Case Ref: EN010119

Date: 22 August 2024

Planning Act 2008 (as amended) – Section 51

Application by North Falls Offshore Wind Farm Ltd for an Order Granting Development Consent for the North Falls Offshore Wind Farm Advice following issue of decision to accept the application for examination.

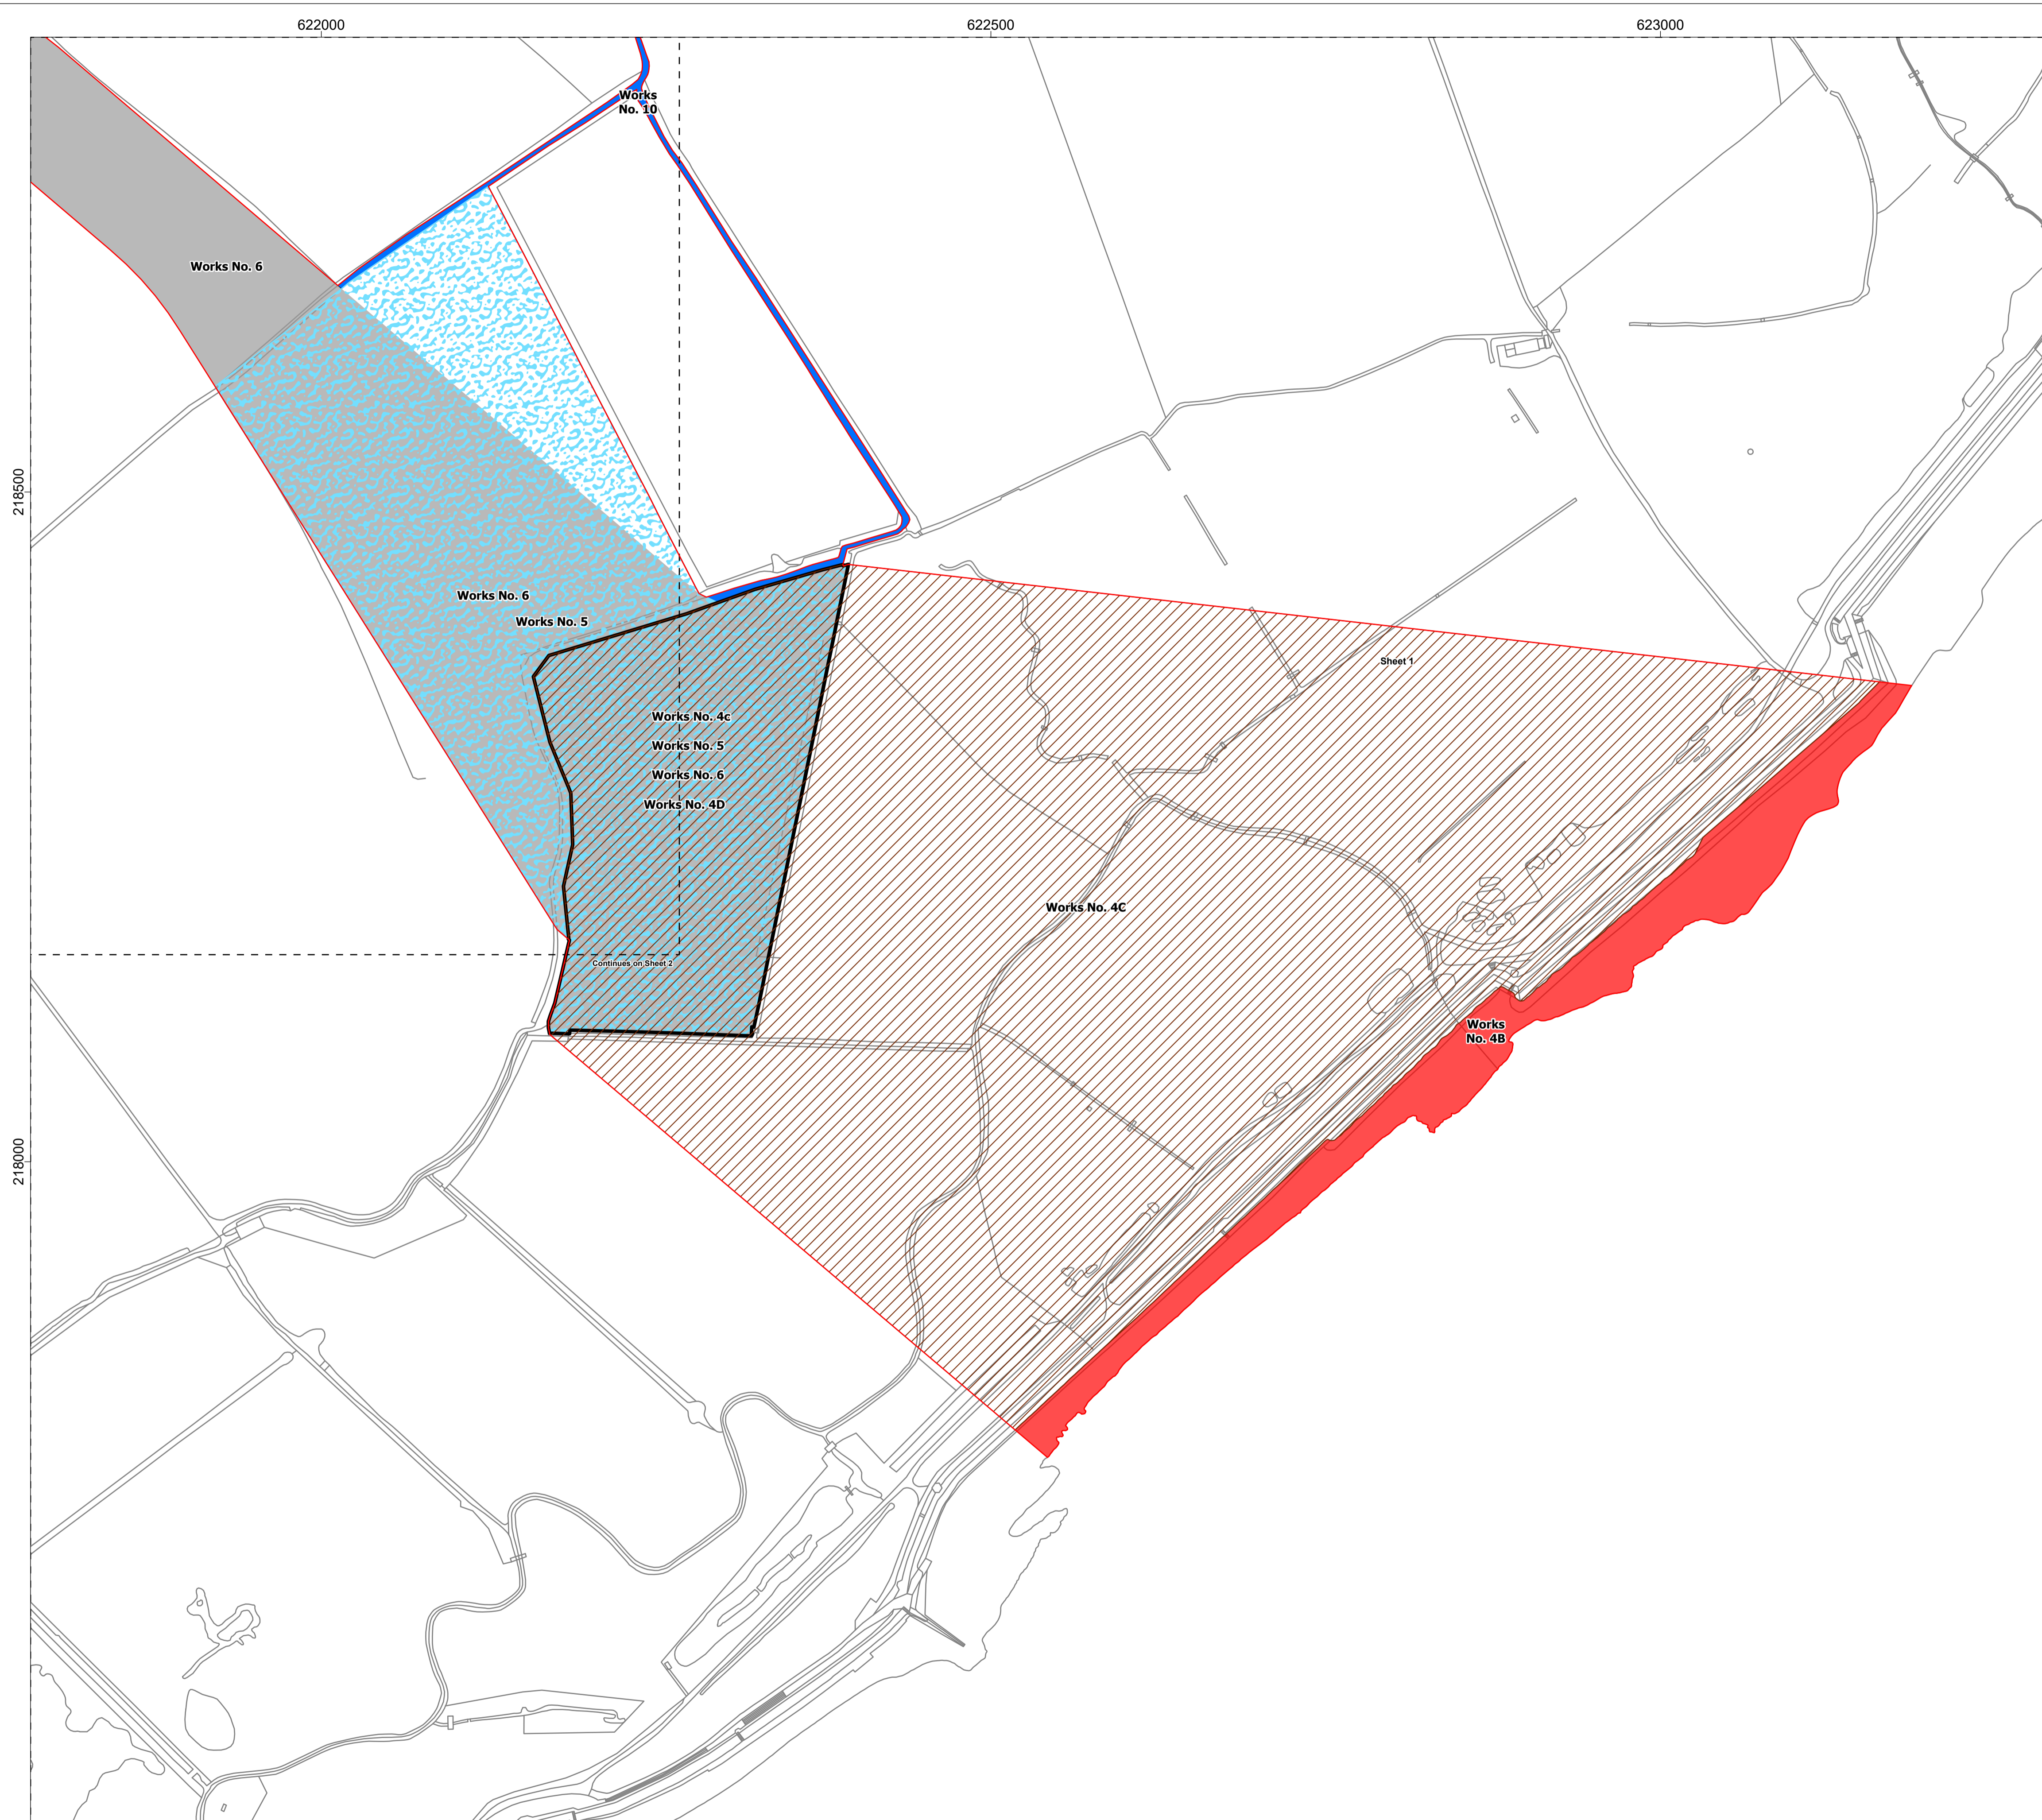
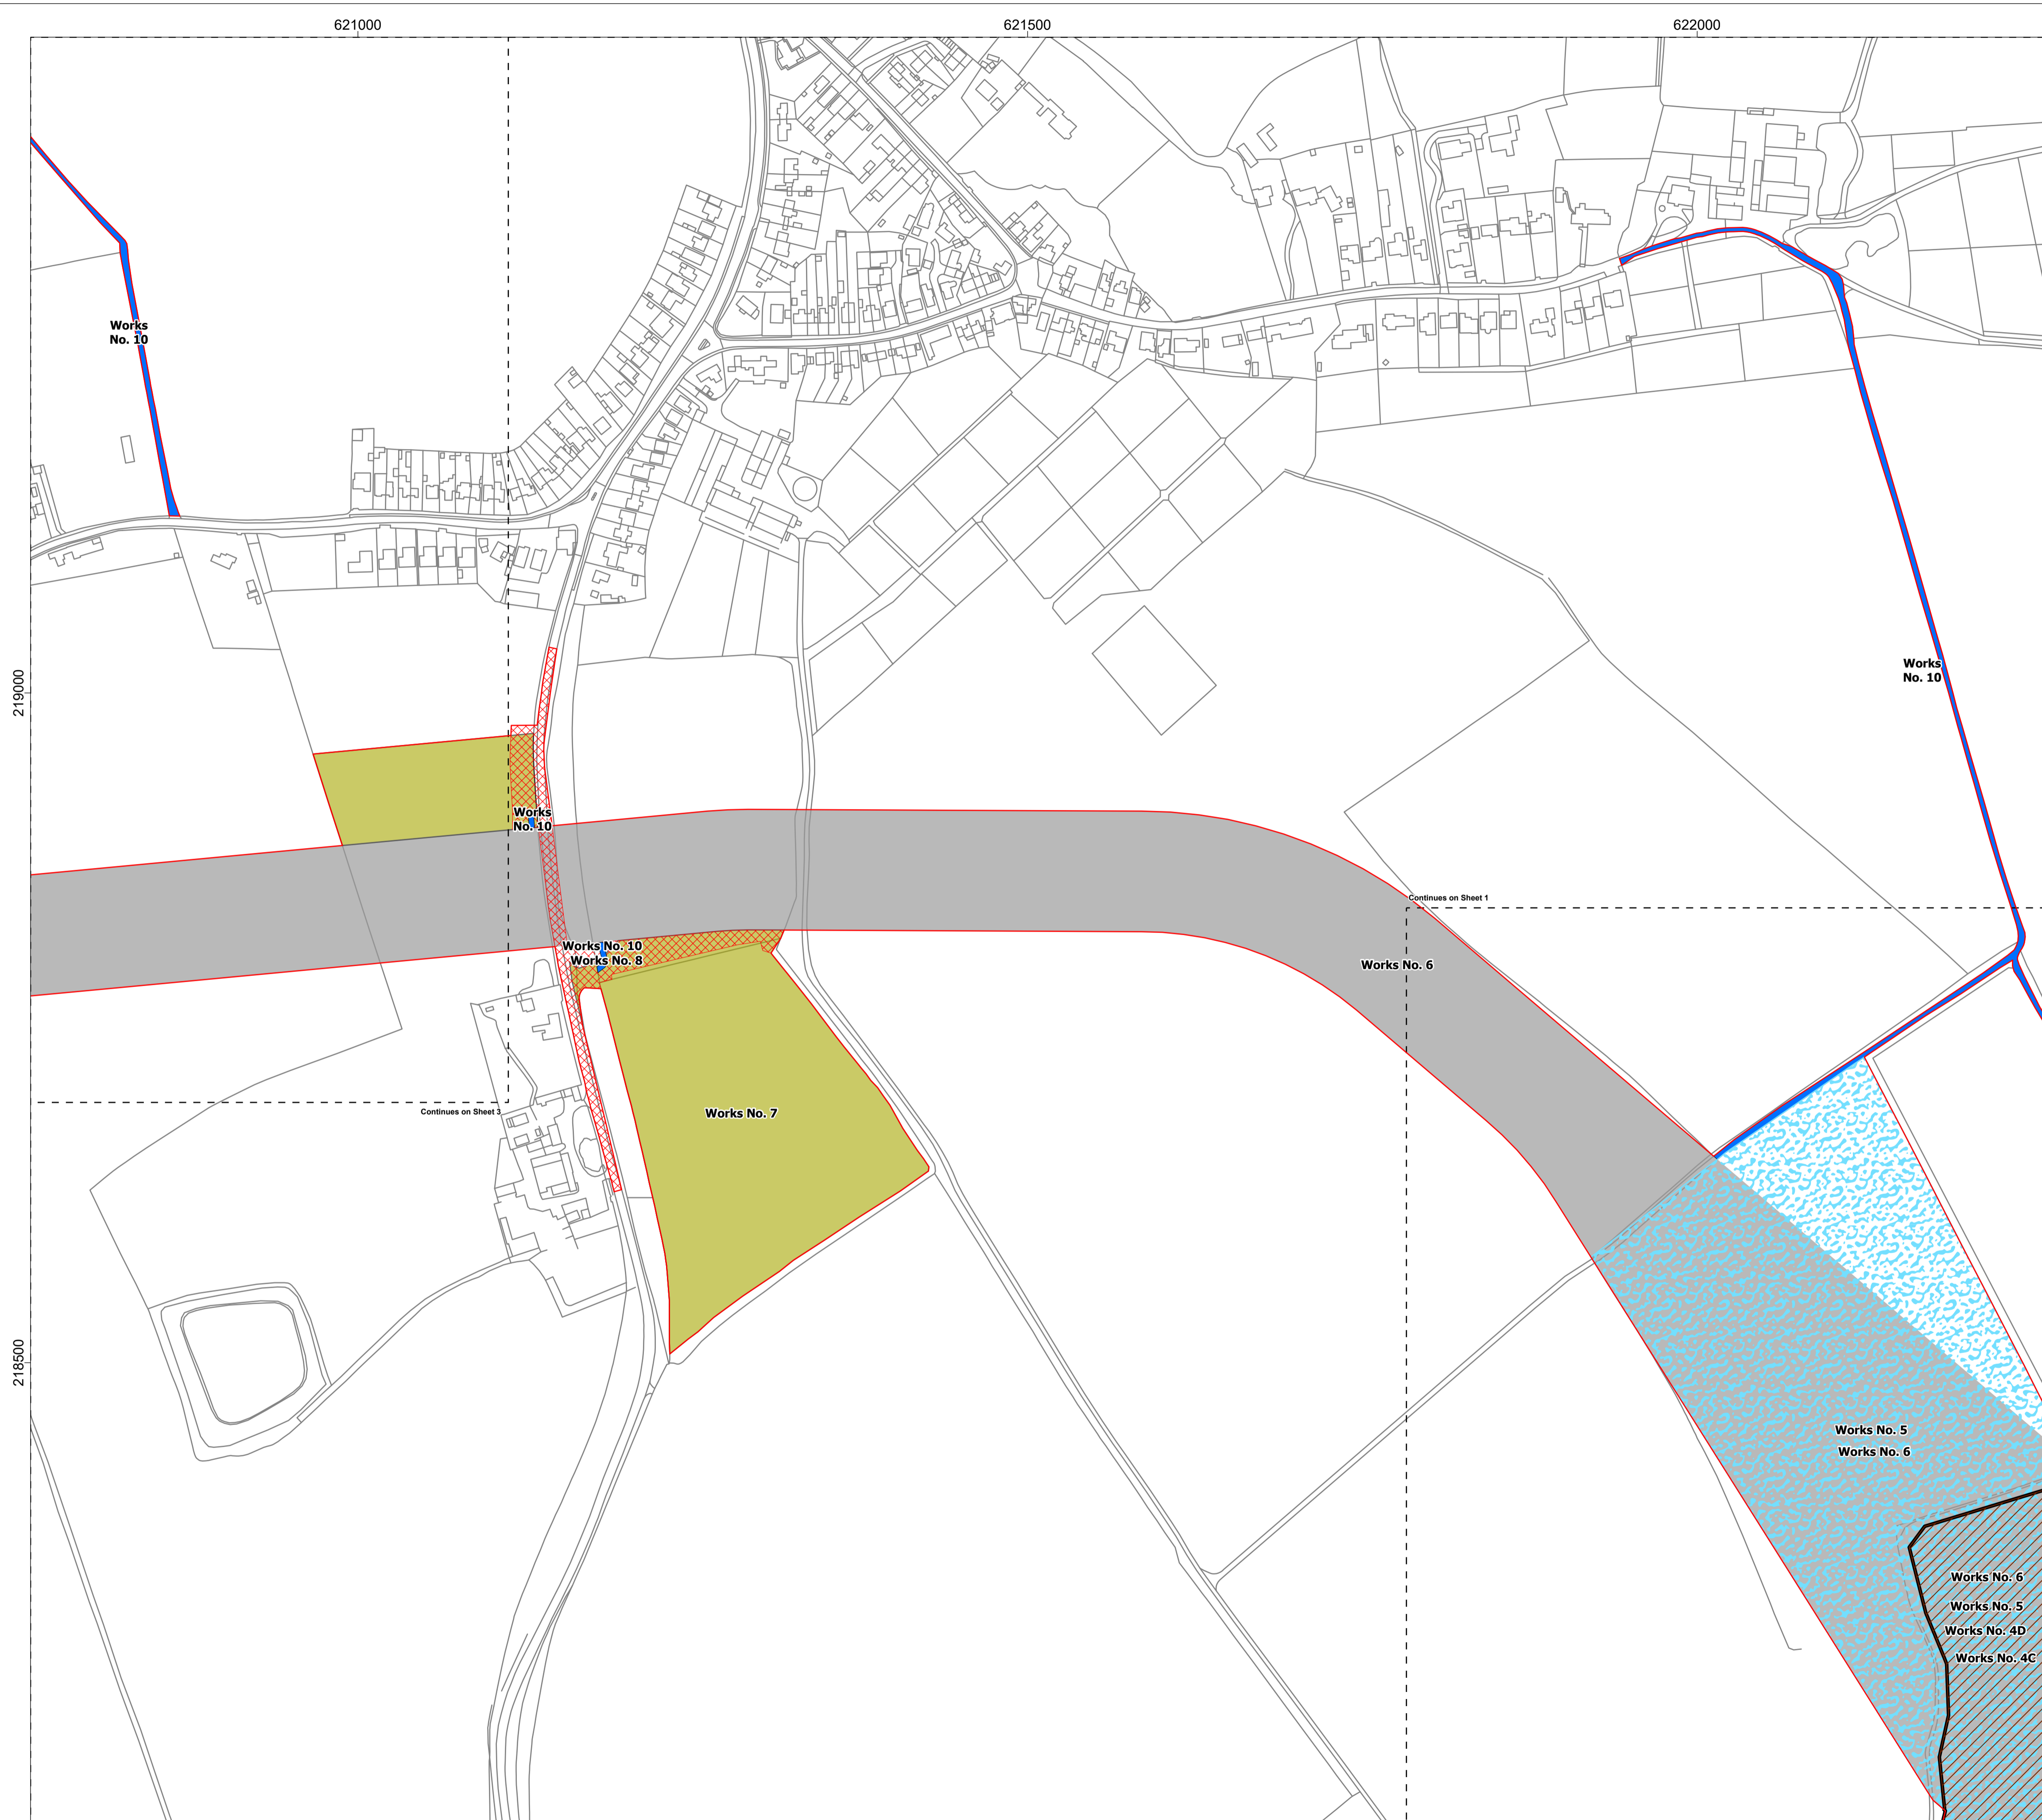
Summary descriptors are not provided for each work area. The Works Plans do not contain any identifying information, such as village or road names, which are shown on the Location Plans. Adding summary descriptors, local place and road names to the Works Plans would aid understanding for stakeholders. Similarly, the location of the 'red line' boundary must be clear in all areas. Once identifying information labels are added to the plans, please ensure that these can be digitally searched. This should be provided to the Planning Inspectorate for publication as early as possible before the commencement of the Examination.
